**KIRKLEES METROPOLITAN COUNCIL
INVESTMENT & REGENERATION SERVICE**

**DELEGATED DECISION FOR APPLICATION FOR CERTIFICATE OF
LAWFUL DEVELOPMENT**

Reference no.: 2021/CL/92008/E

Description: Certificate of lawfulness for proposed erection of
single storey rear extension and detached garage

SITE PLAN 1:500

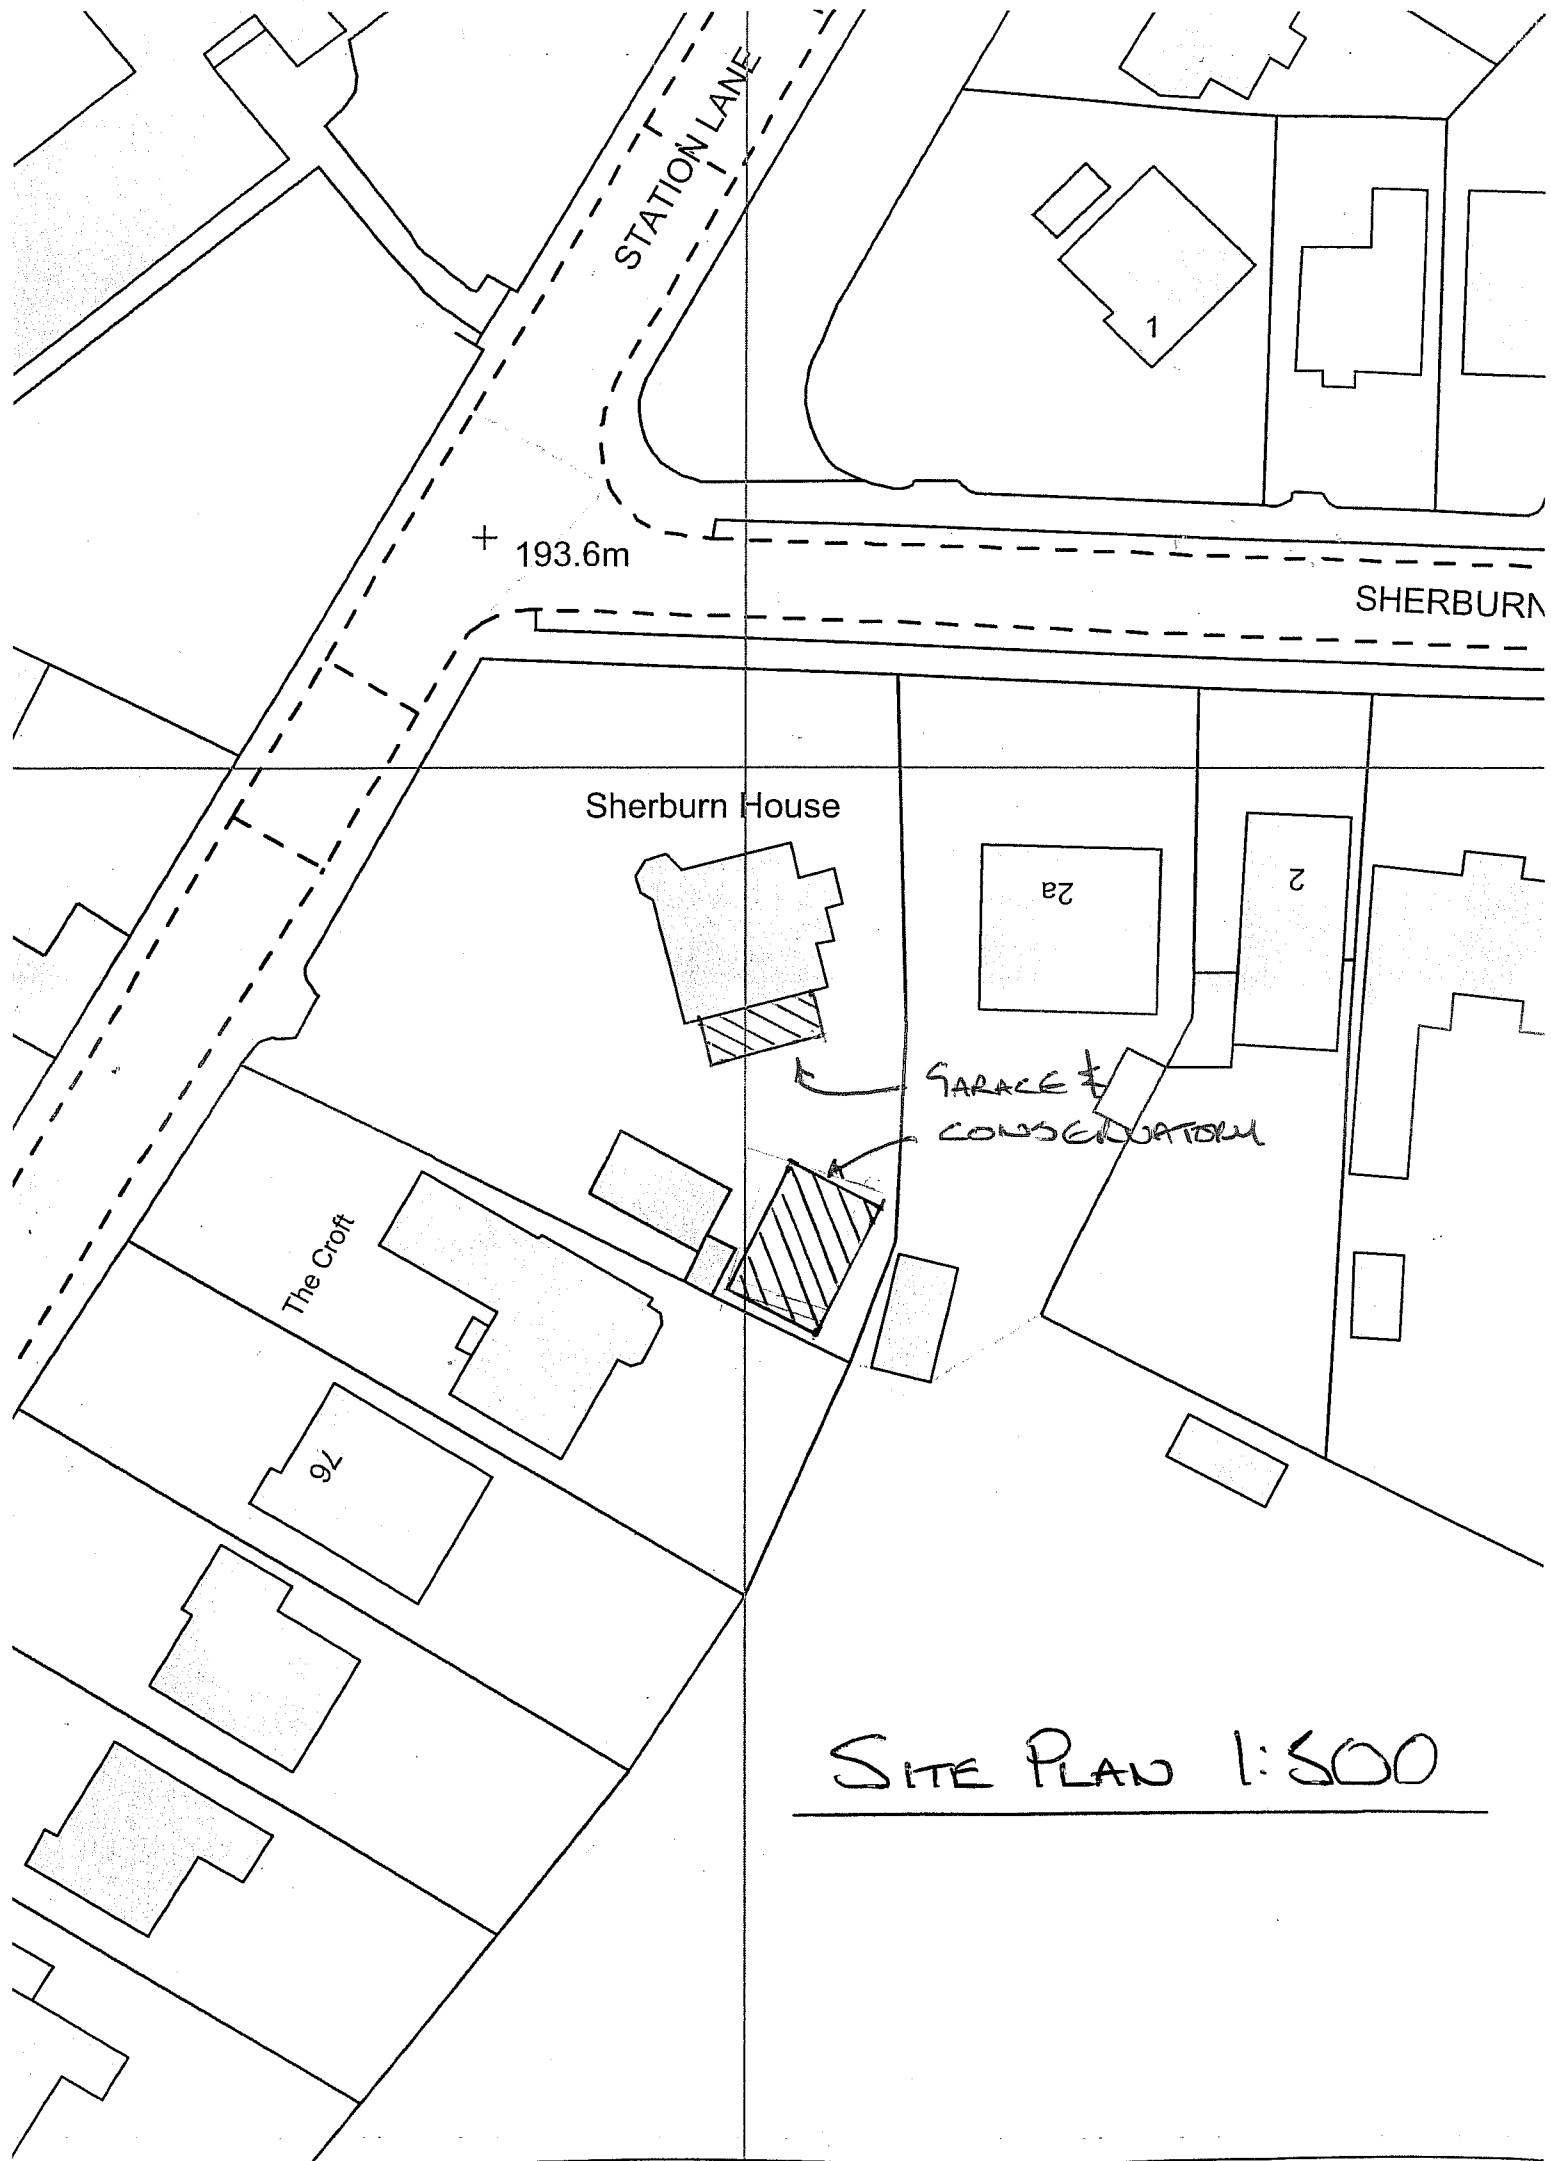
Comment *As can be seen from the location plan provided by the applicant, the proposed extensions would not take up more than 50% of the area of the curtilage of the dwellinghouse.*

Comment The original curtilage would have been approx..1221sqm. The existing outbuilding cover 30sqm and the proposed garage & extension would add approx. 85sqm. The development proposed together with the existing d garage equates significantly less than 50% of the original 1262 sqm.
